Comment from Greenspace

APPLICATION NO: LU/201/16/RES

Site Address: Windroos Nursery Worthing Road Littlehampton
BN17 6LY

Description of Works: Approval of reserved matters following outline consent LU/229/10/ for appearance, landscaping, layout & scale for 84 No. dwellings

CLIENT	STUART & MARCIA LYONS		
PROJECT	WINDROOS, LITTLEHAMPTON		
TITLE	PLANTING PLAN 2 of 2		
NUMBER	13121 - P.10.007 P1		
DATE	SCALE	STATUS	DRAWN / CHECKED
July 2016	1:250 @ A1	PLANNING	AH/DR

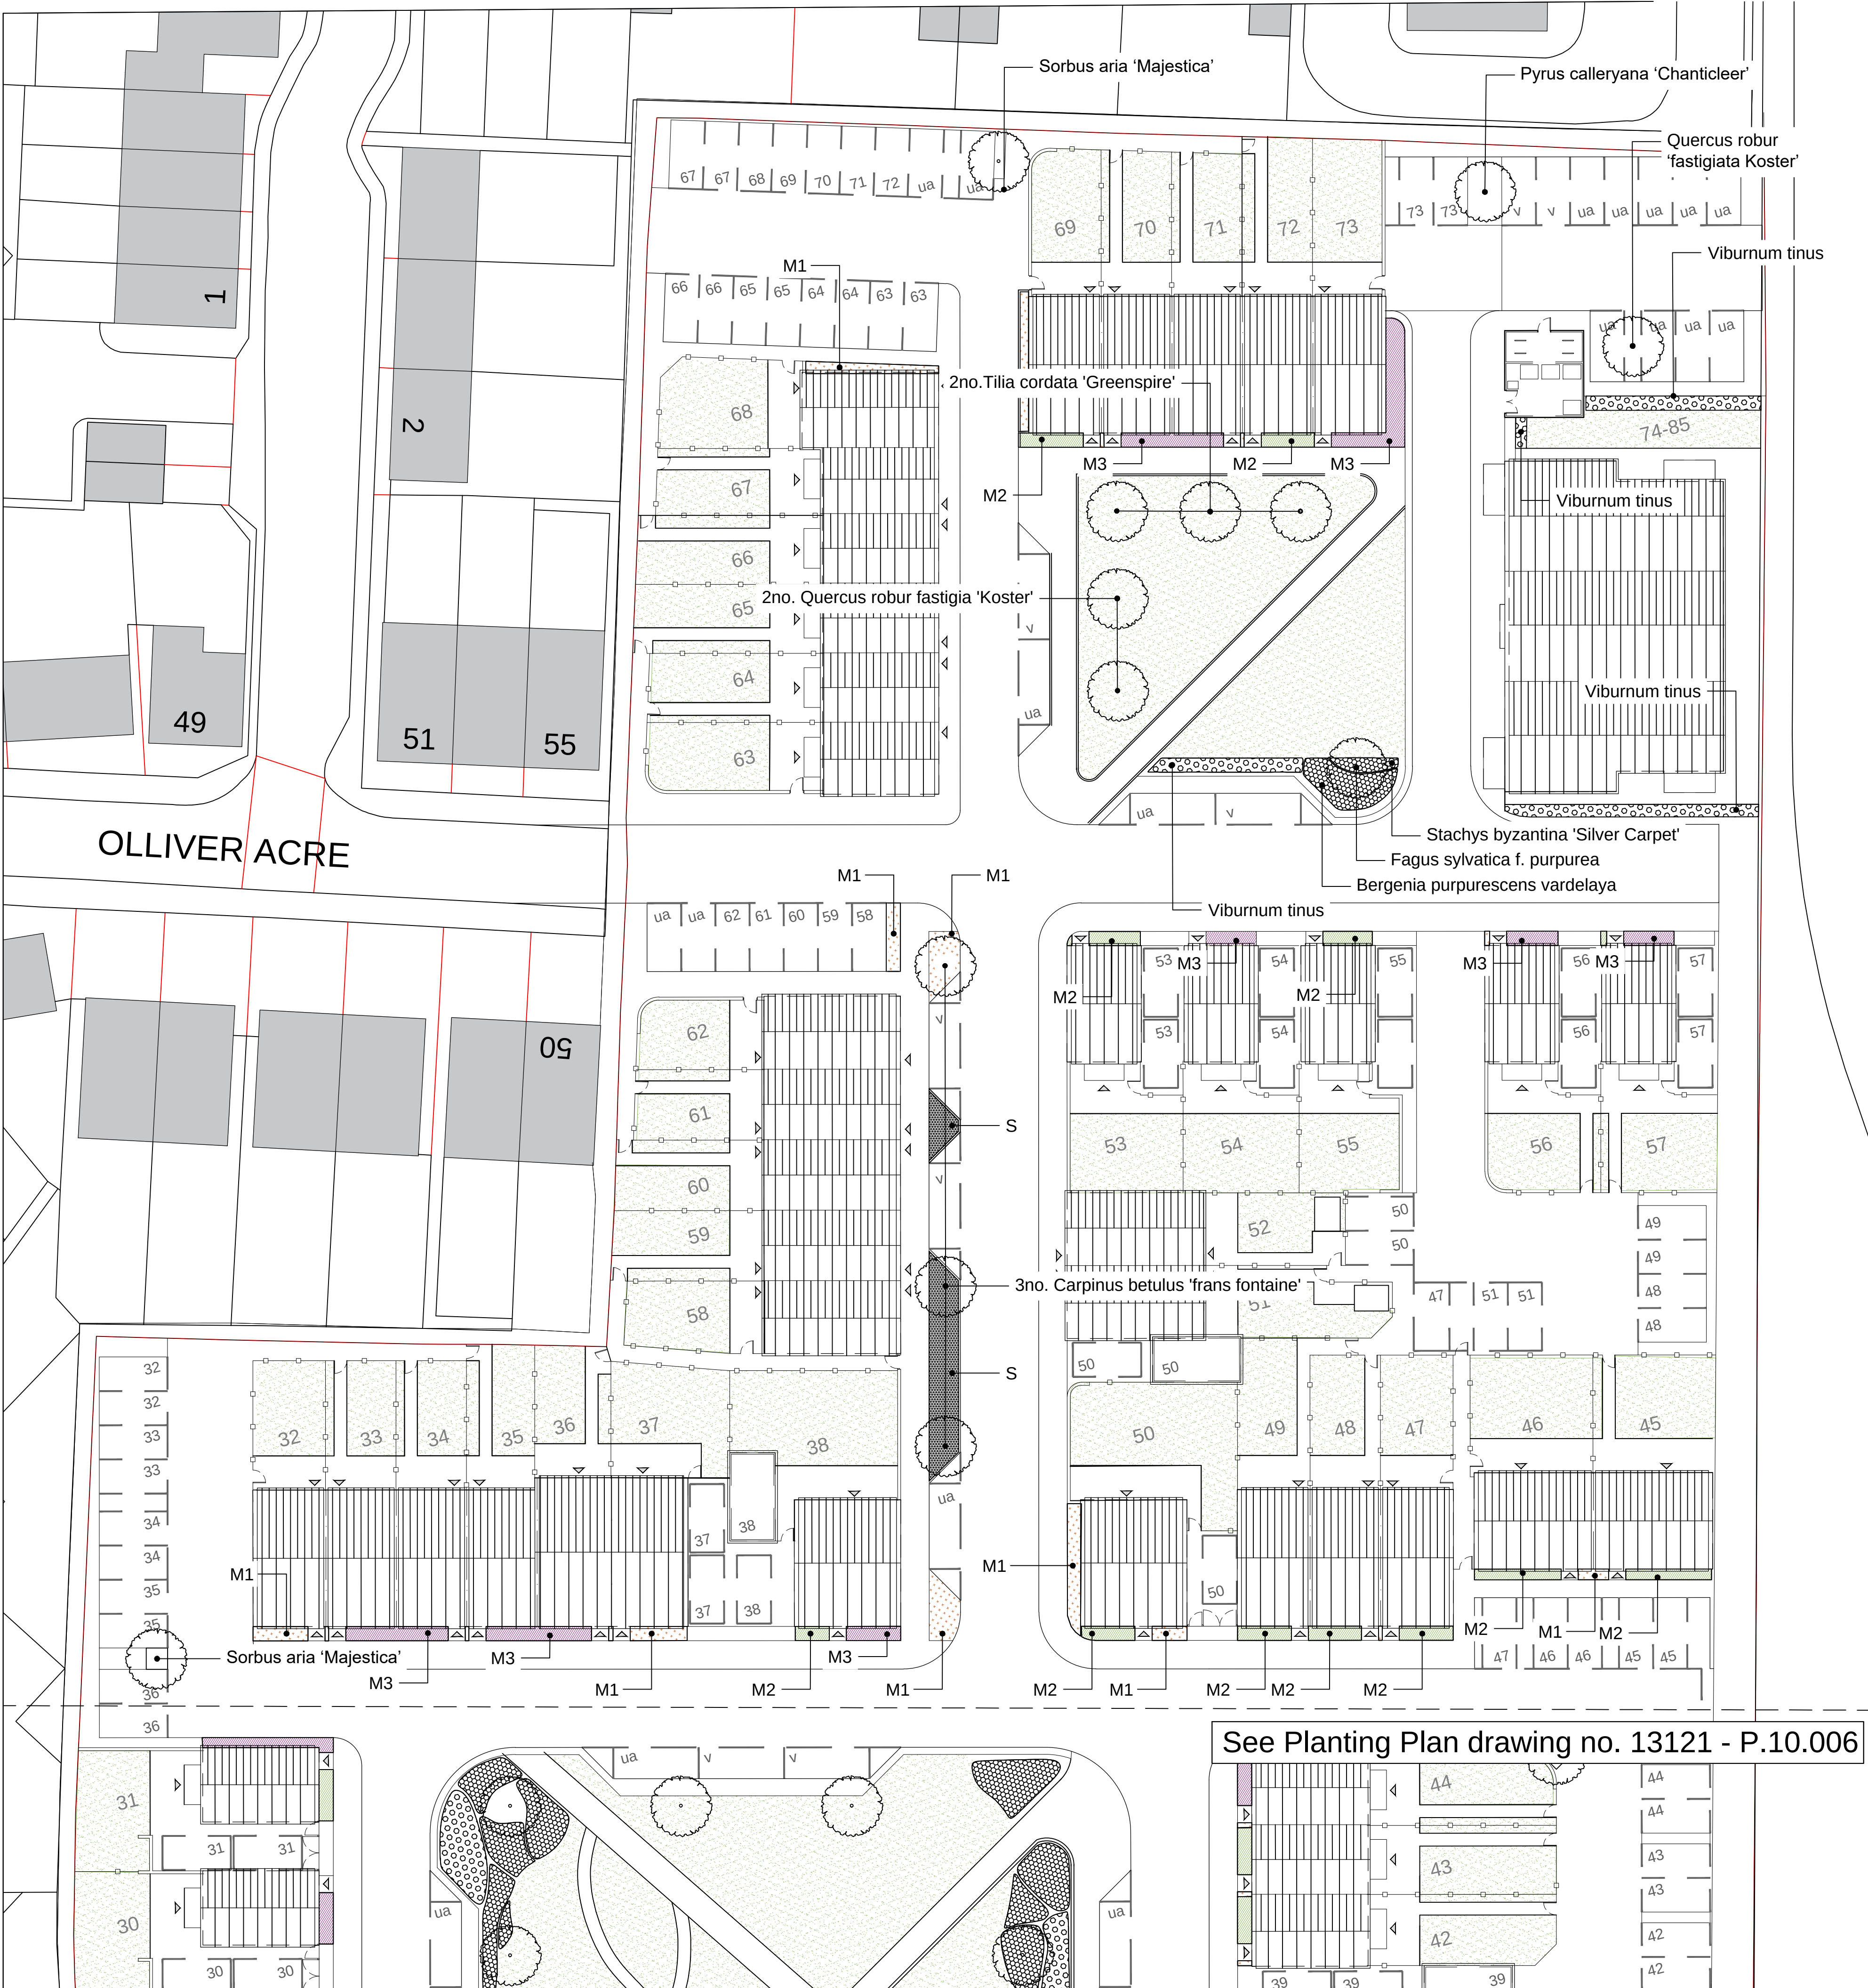
This application has included a detailed and well thought out scheme of trees and shrubs that are both suitable and fitting for location. The schedules and detail contained within P3 revised drawings dwg 13121-P.10.006 P3 & dwg 13121-P.10.007 P3 does now contain specific quantities, which we had previously requested in plan form.

I would recommend therefore now recommend that the reserved matters application relating to landscaping under application LU/201/16/RES following outline consent LU/229/10 is approved.
